PHO M2799

**PACIFIC HIGHWAY UPGRADE SAPPHIRE TO WOOLGOOLGA PROJECT
PROPOSED MODIFICATION OF THE PROJECT APPROVAL**

The Roads and Maritime Services (RMS) are requesting a modification of the project approval for the Sapphire to Woolgoolga Pacific Highway upgrade project to incorporate a rest area at Arrawarra.

Figure 6: Layout of Proposed Rest Area (Base Image Source: EA 2011)

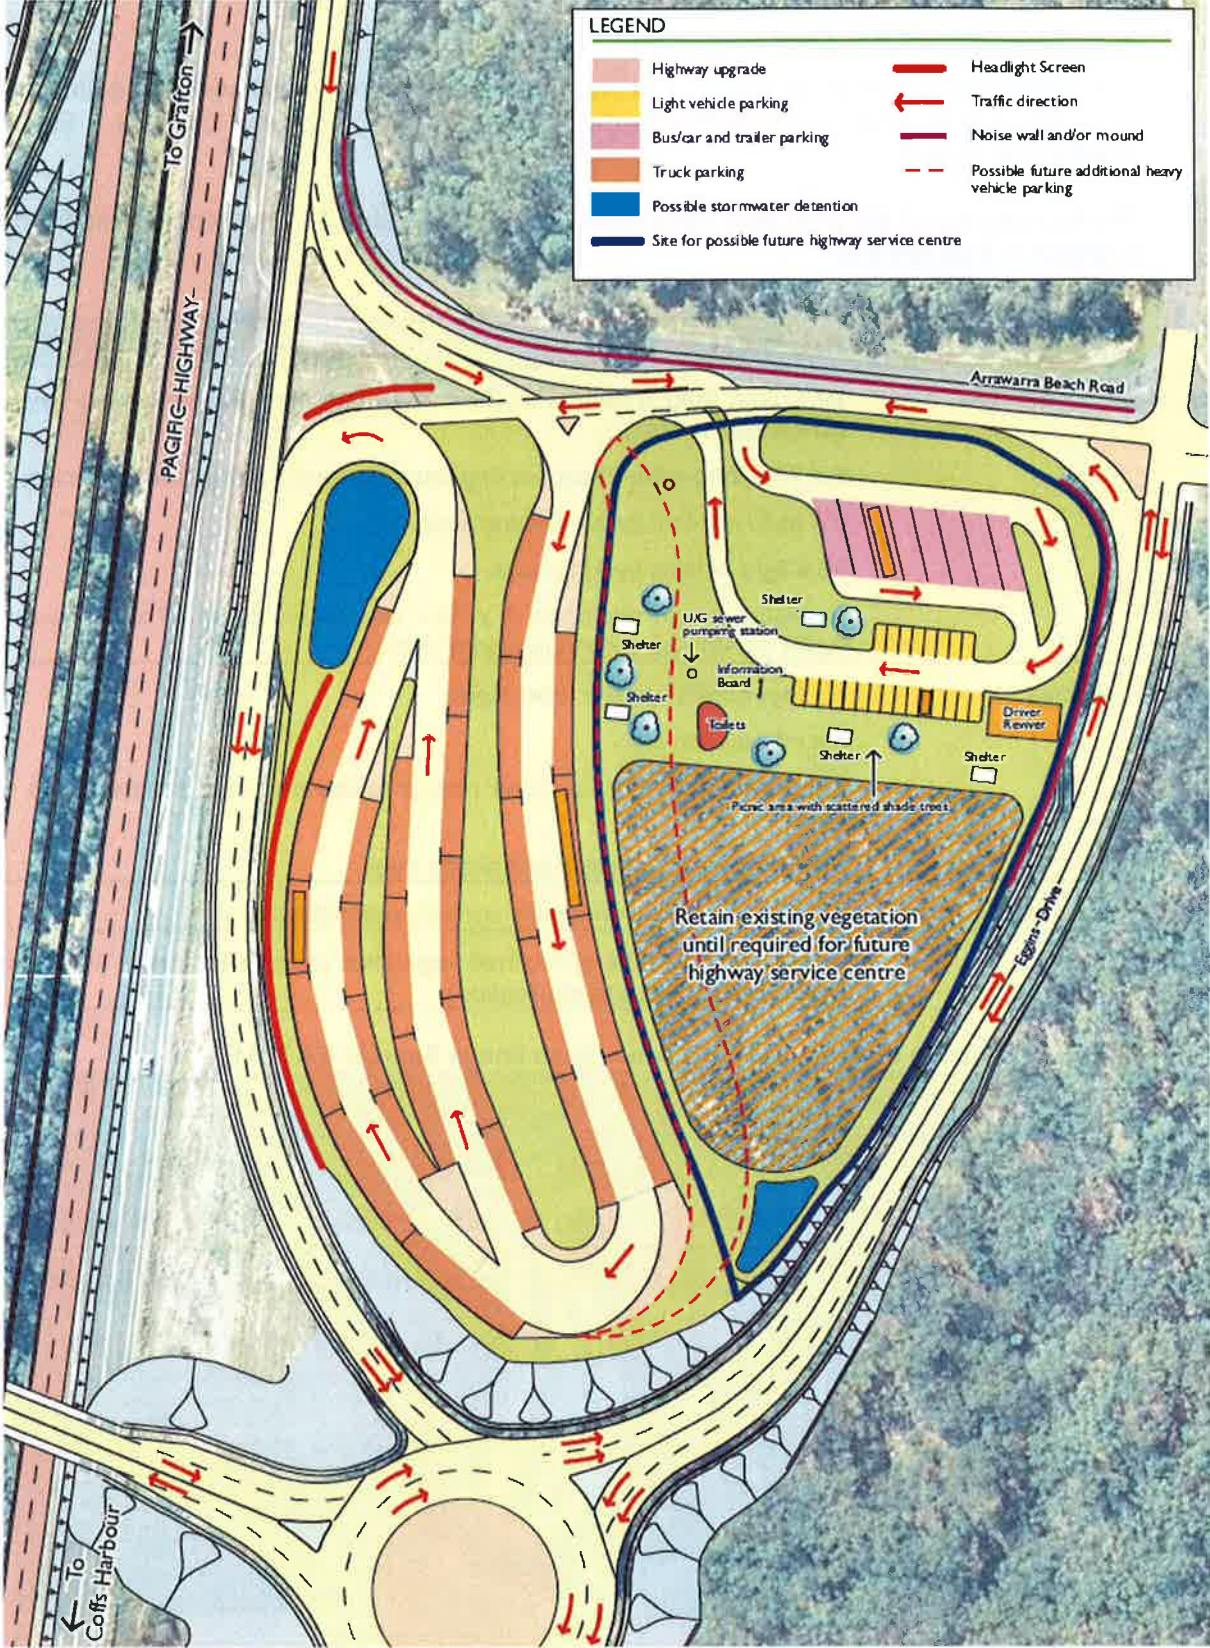
Note 5 on figure 6.1 refers to "possible stormwater detention basins" what alternatives are proposed if these are not possible?

- Treatment measures including vegetated swale drains have been designed in lieu of detention basins due to the physical constraints on the site. RMS propose to install a bio-retention system along with the vegetated swales to treat the runoff. Bio-retention systems are able to remove stormwater pollutants through physical, biological and chemical processes. Modelling of a bio-retention system at this site has shown that the following pollution reductions are expected to be achieved from the proposed stormwater treatment measures:
 - o 83.6% of total suspended solids (NSW target of 85% removal);
 - o 64.8% of total phosphorus (NSW target 65% removal)
 - o 33.8% of total nitrogen (NSW target 45% removal).
 - o 80-95% of total petroleum hydrocarbons.
